DECISION DELEGATED TO HEAD OF PLANNING

Application No: H01-0733-24 **Applicant:** Mr C Harris
Proposal: Proposed extension & alterations
Location: 32 The Pastures Cowbit Spalding
Terminal Date: 22nd October 2024

CASE OFFICER ASSESSMENT

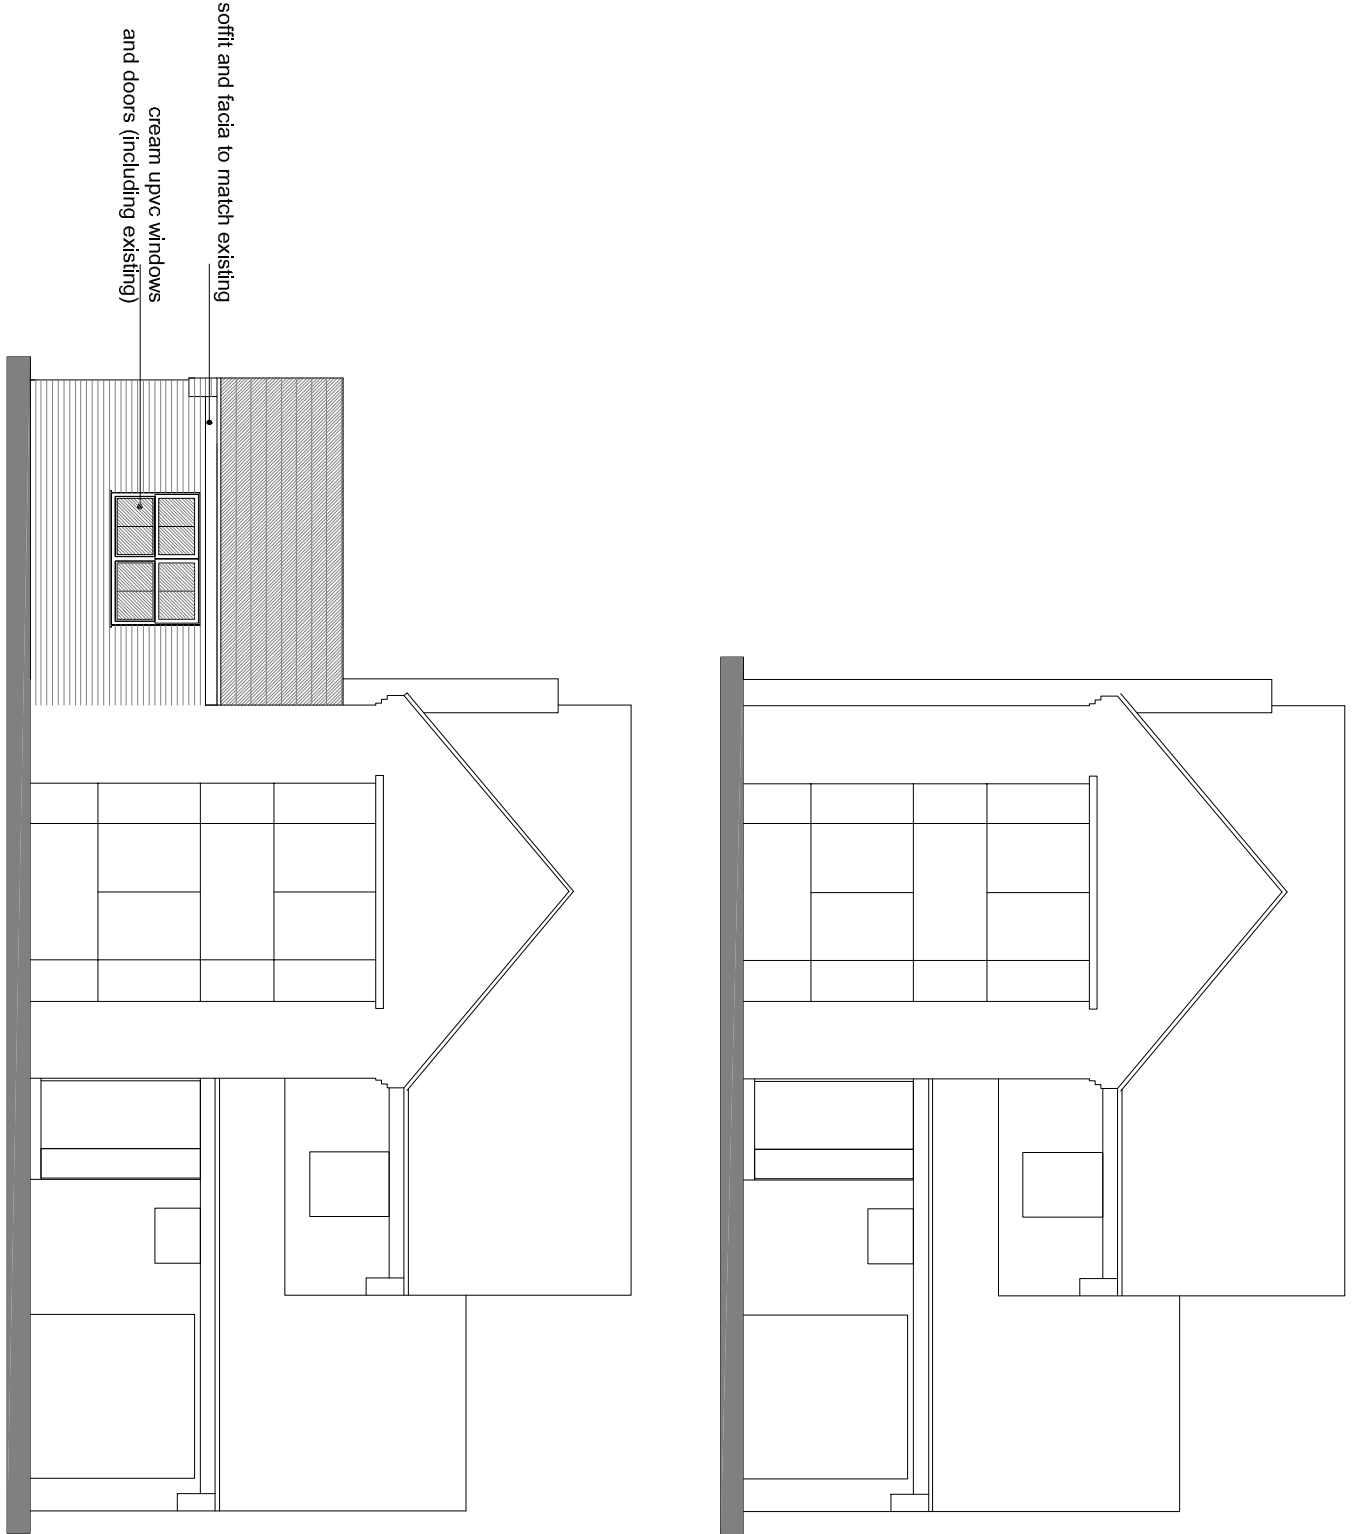
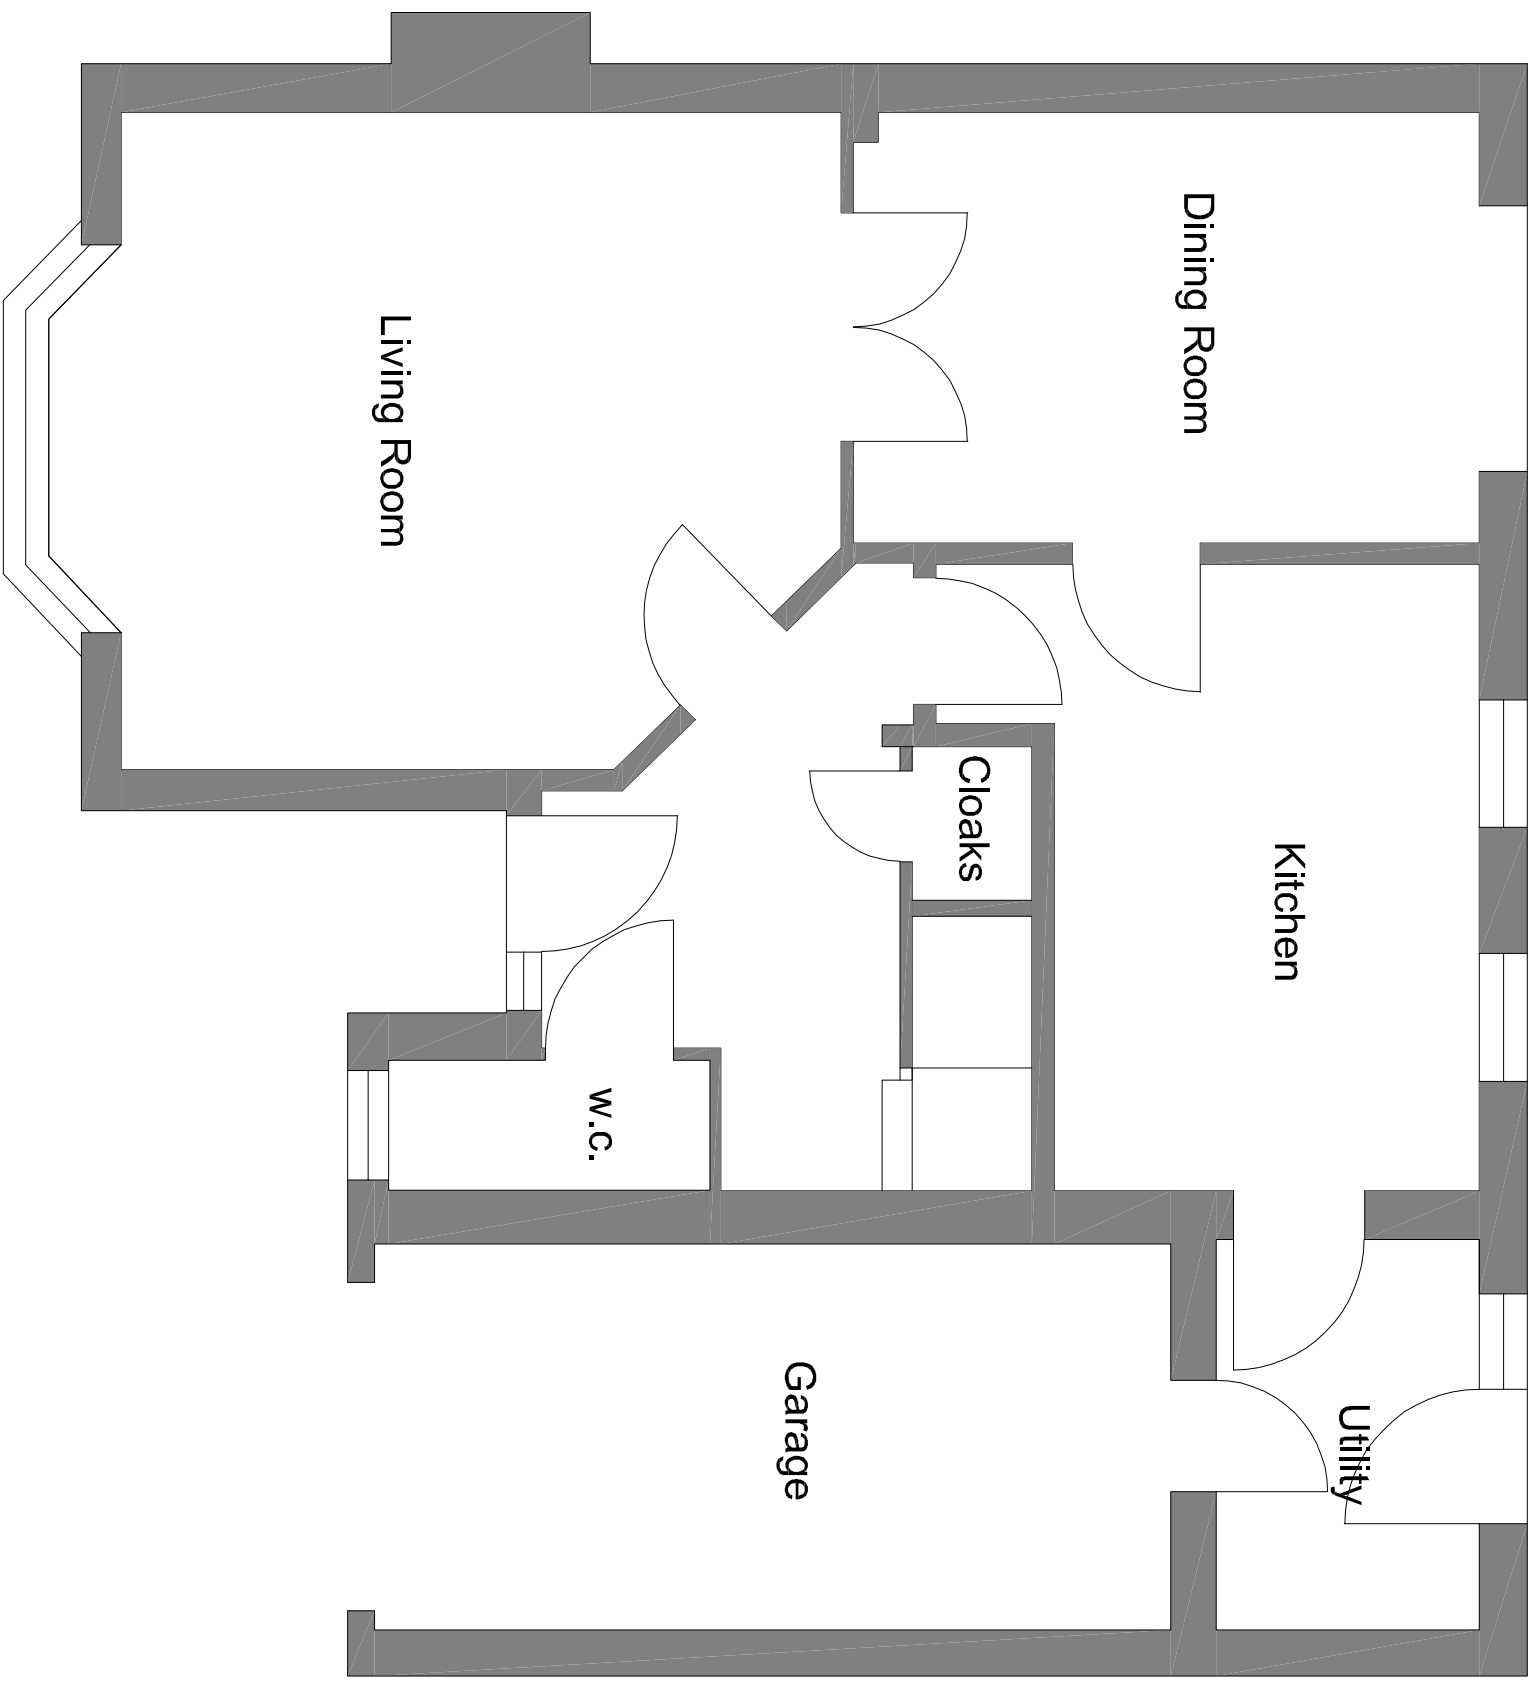
The proposed extension will match the existing materials throughout which ensures the development remains in keeping with the host property and the character of the area. They will use facing brickwork, roof coverings, cream uPVC windows and doors and this includes the existing. There will also be Velux style roof windows within the extension.

It shall protrude from the side by around 4300mm and will have a full length of 11360mm spanning from the front elevation and sticking out slightly by around 1800mm to the rear. The rear width will be around 7700mm and will feature bi-fold doors for access into the garden. As the extension is only single storey, the height will be around half of the existing dwelling being 4100mm to the ridge and 2500mm to the eaves. This extension will be proportionate in relation to the host dwelling and is smaller in scale than the previous approval further outlining its acceptability and suitability.

There are some internal alterations being carried out as part of the proposal, the living room will be converted to a dining area with the extension adjacent to this being a snug. The dining room to the rear of this will not act as a living room and opened up into the extension as well. These alterations are considered to be acceptable and will not harm the street scene or locality as they are purely internal changes only.

There are no side elevation windows within the extension with windows only being set on the front and rear elevations - due to the positioning of the extension and the windows there is no material overlooking that will occur as a result of the development being carried out. Furthermore, as the extension is only single storey and there are more than adequate distances between other properties there should be no material overshadowing to surrounding neighbours.
